## 23.0 CUMULATIVE AND COMBINED EFFECTS

23.1.4 This is a revised version of the Cumulative and Combined Effects Assessment (Original Cumulative and Combined Effects Assessment is [APP-076]), submitted to the Planning Inspectorate at Deadline 5 of the Examination. This document and its appendices have accordingly been updated by the Applicant to:

**Table 23-1: Written Questions / Relevant Representations applicable to the Deadline 5 update**

Figure 23-3 (Sheet 2 of 3)

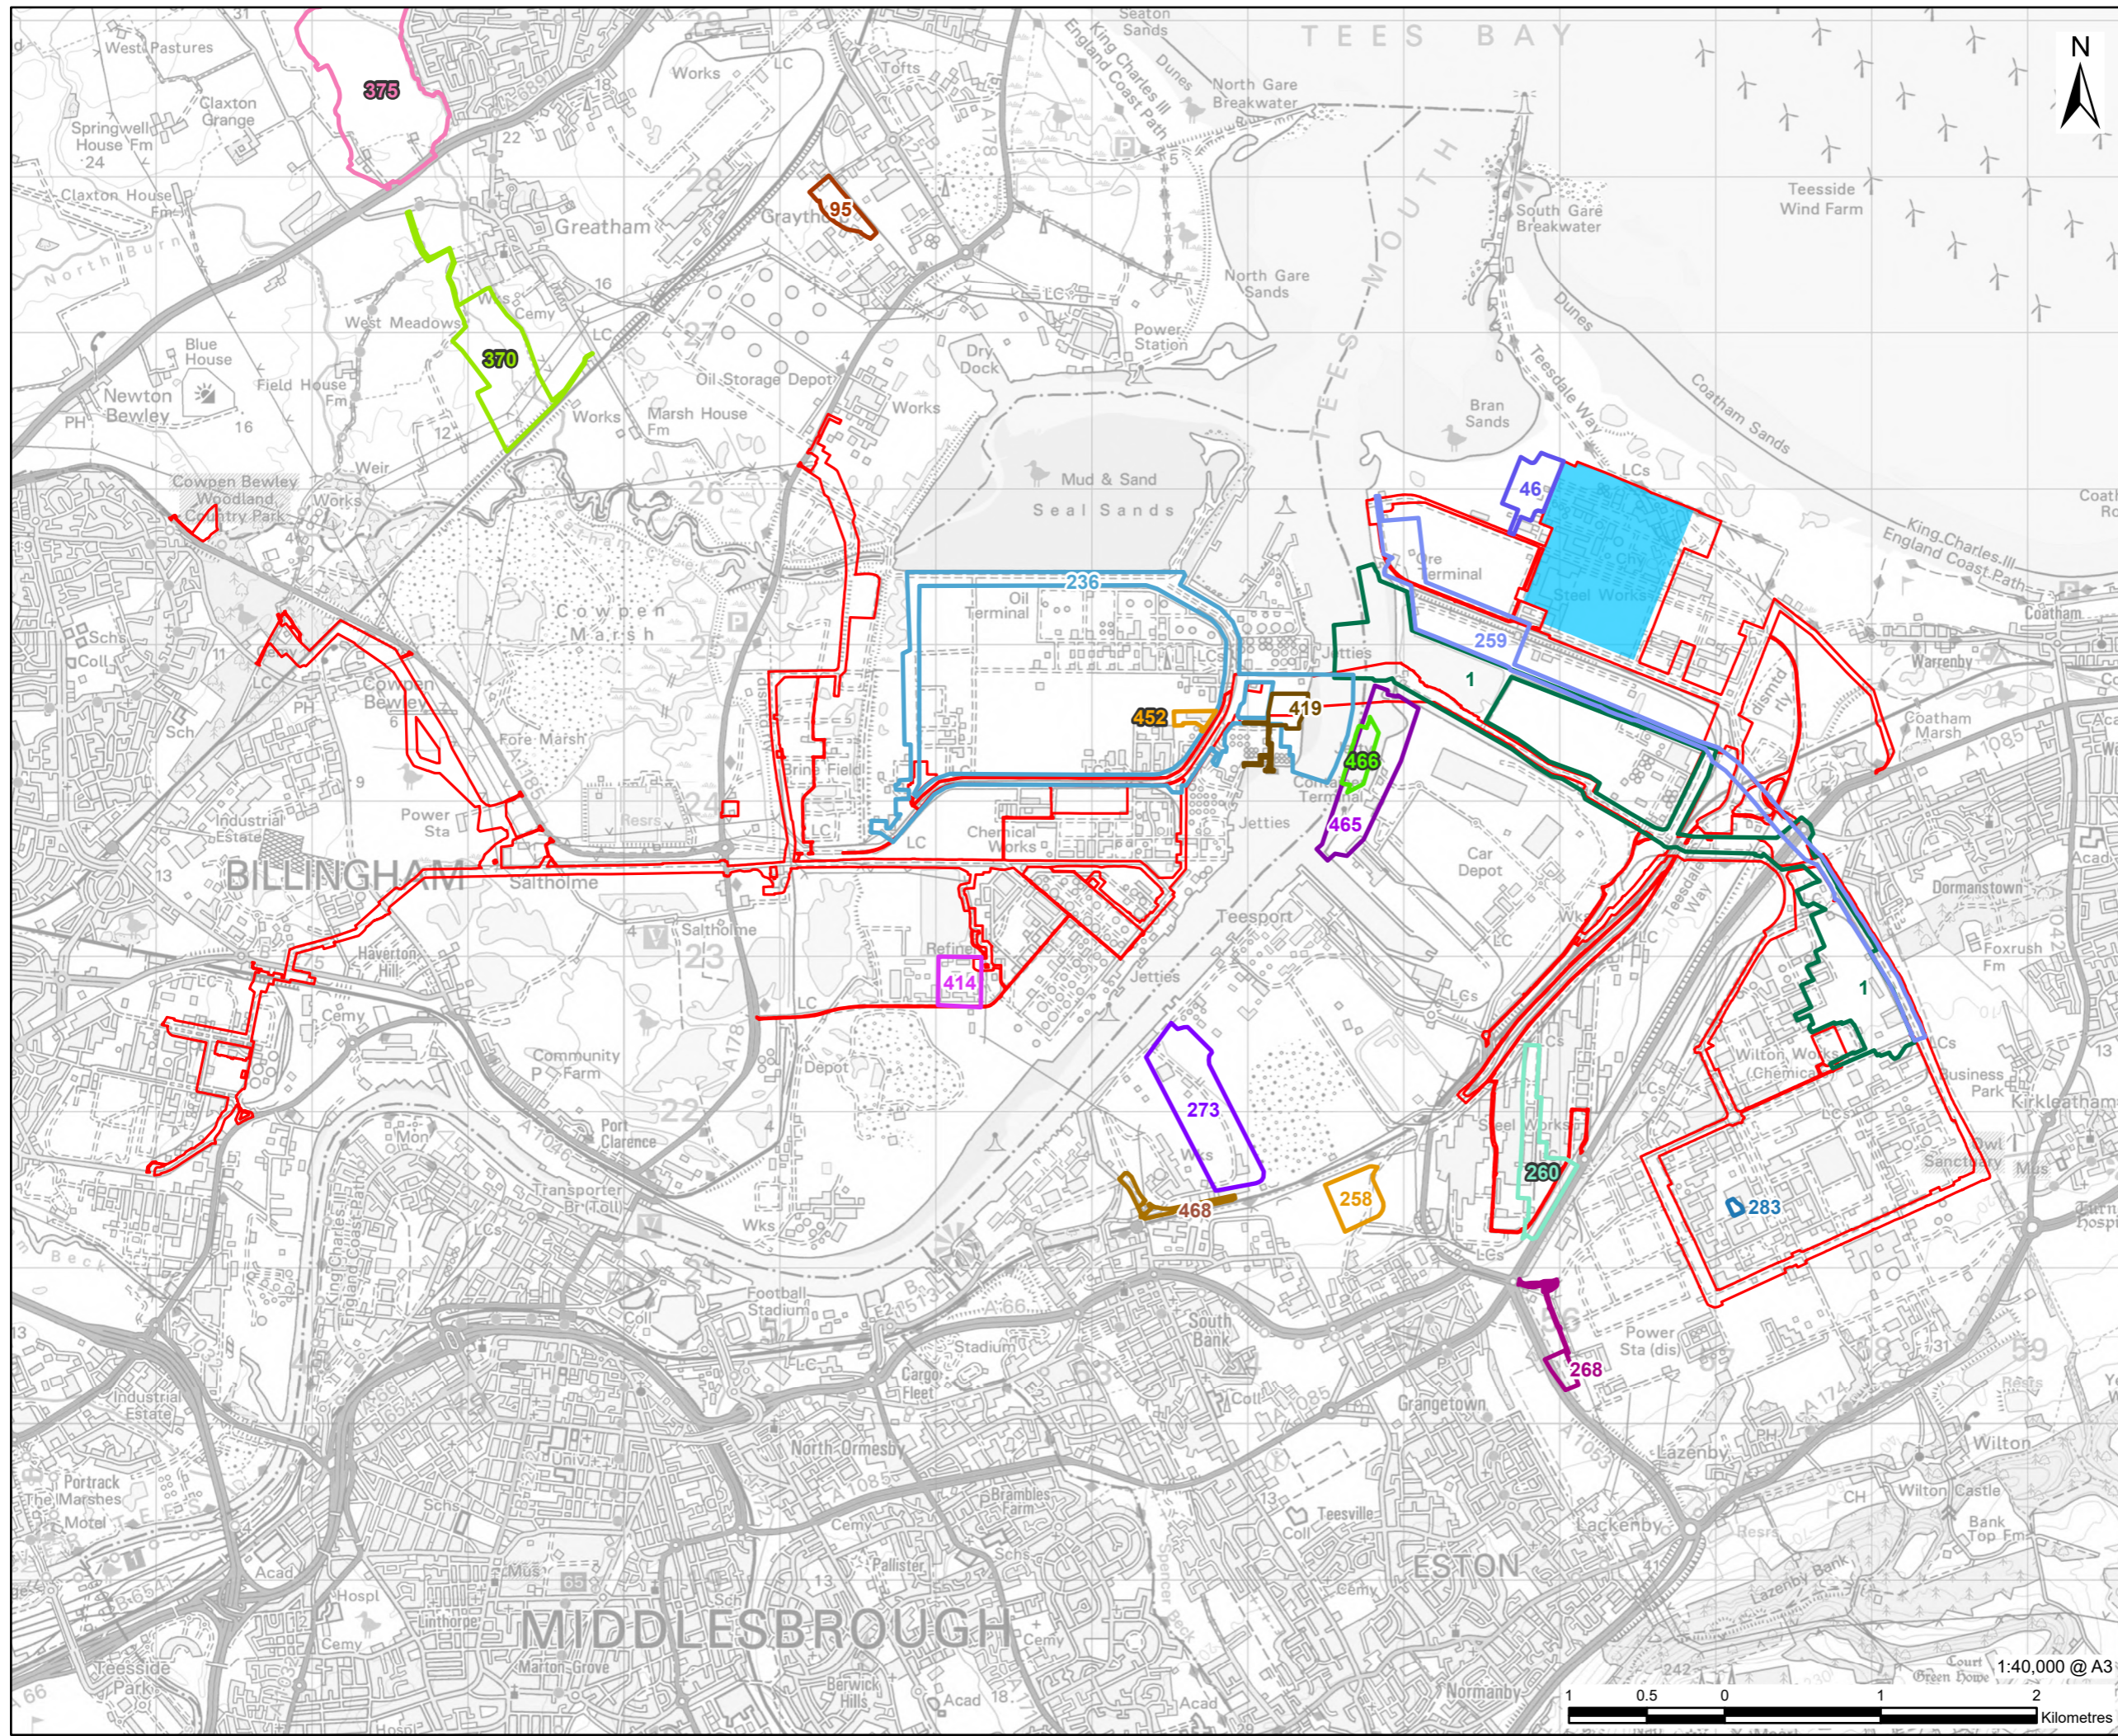
| REFERENCE | QUESTION   | RESPONSE   | UPDATE   |
|-----------|--|--|--|
| Q1.8.3    | <p>Paragraph 23.3.19 of ES Chapter 23 (Cumulative and Combined Effects) [APP-076] states that the long list of developments was updated up to a cut-off point of 1 November 2023. It does not state whether the Applicant proposes to keep the list under review during the Examination.</p> <p>Bearing the above in mind, please explain the steps that it will take to keep information about other developments used in the cumulative effects assessment (ES Chapter 23 [APP-076]) under review, including how any changes would be addressed and reported to the examination.</p> | <p>A re-review of all Other Developments currently captured within the Long List present in Appendix 23A [APP-221] to account for any updates to the status of the respective planning applications is also being conducted as part of this update. This will be reported to the Examination in the format of an updated Chapter 23 and its relevant figures and appendices, thus superseding the versions that were submitted with the DCO Application [APP-076] [APP-180 to APP-182] [APP-221 to APP-225].</p> <p>The updated Assessment will also account for the changes set out in the Change Notification, if accepted into Examination by the Inspectorate.</p>   | This updated Cumulative and Combined Effects Assessment accounts for developments submitted after 01/11/2023 up to 18/09/2024 and assesses them in the context of the Proposed Development (including accounting for the changes set out in the Changes Application Report [CR1-044] as they were accepted into Examination by the Inspectorate. |

- 23.1.6 The updated Cumulative and Combined Effects Assessment in response to WQ 1.8.3 has led to Appendices 23A, 23B, 23C, 23D, and 23E (ES Volume III, EN070009/APP/6.4) being updated to account for additional Other Developments being added to the longlist and shortlist as well as updates to the status of already captured Other Developments.
- 23.1.7 In addition to the amendments made in response to the WQs, Figure 23-3 (ES Volume II, EN070009/APP/6.3) has been updated to show the additions to the shortlist (Appendix 23C (ES Volume III, EN070009/APP/6.4)). Sheets 1 of Figure 23-3 remains as it was in the Original ES's Figure 23-3 [APP-182] however Sheets 2 and 3 have been updated to include the additions to the shortlist.
